Planning Applications 2025/44/92737E - Flood Exceedance Plan

Re: Drainage Plan [id1113906] 13/11/2025-PV2511-APP-92-XX-DR-C-2501-P02
Flood Exceedance Plan.

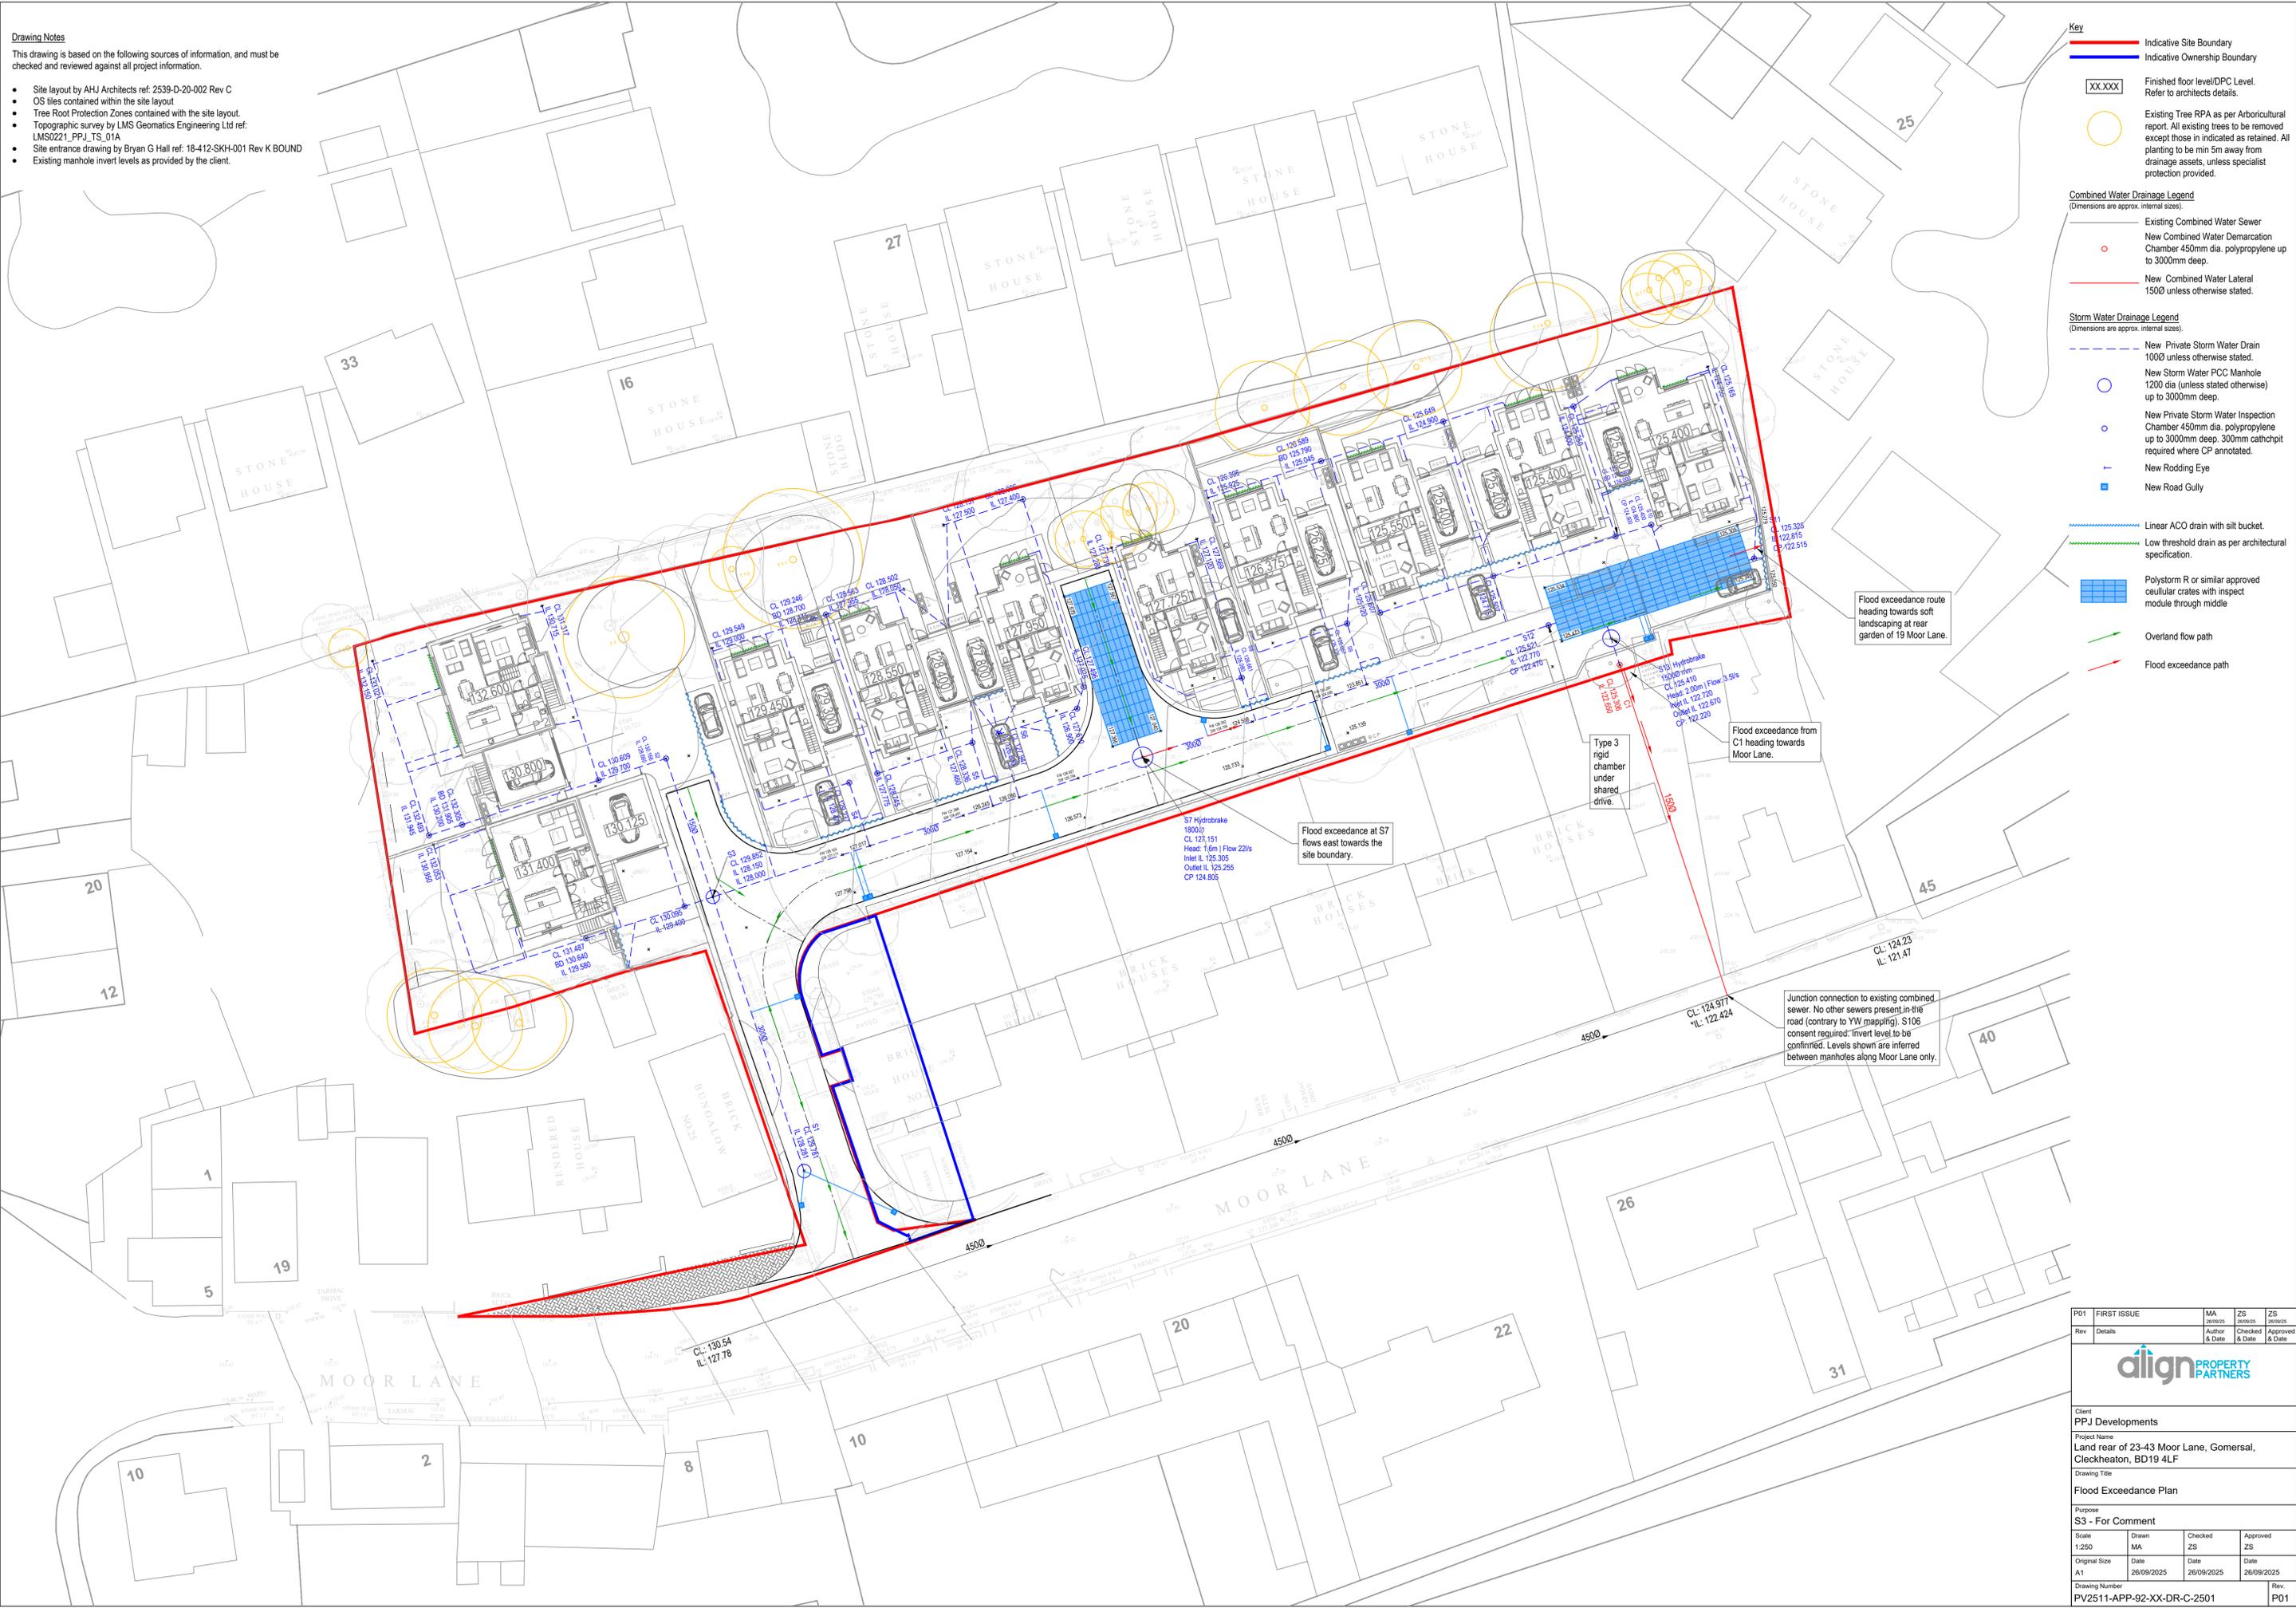
The above exceedance plan is actually showing and stating that the flood exceedance route is being directed to 21 Summerdale's private garden. On the above plan there is a red arrow indicating the direction of the flood exceedance flow and also states "Flood exceedance route heading towards soft landscaping at rear garden of 21 Summerdale".

This developer's flood exceedance plan is clearly increasing the risk of flood to my property and is therefore not complying with the requirements of the National Planning Policy Framework.

A developer cannot unilaterally state that a flood exceedance route will be directed into a private garden without appropriate legal rights and permissions.

My husband and I have **NOT** been approached for permission to use our garden for this flood exceedance route and I am formally informing you, Kirklees Council, that we do **NOT** give permission for this flood exceedance to be directed towards or be allowed to access our property.

As the other drainage pipework from this development is being directed through 41 Moor Lane's garden to Moor Lane and as of 28th November 2025 this is a **vacant council owned property** which is being refurbished having new fencing, gates and gardening. Why haven't Kirklees Council used this garden for the flood exceedance route?

This developer is clearly increasing the flood risk on third party properties and designing a flood exceedance route to flow into neighbouring property.

How can a plan, that is supposed to be there in perpetuity, be based on something that is outside the developers control and based on something which could be changed by the current or future owners of this property, i.e. soft landscaping removed (flagging etc.)?
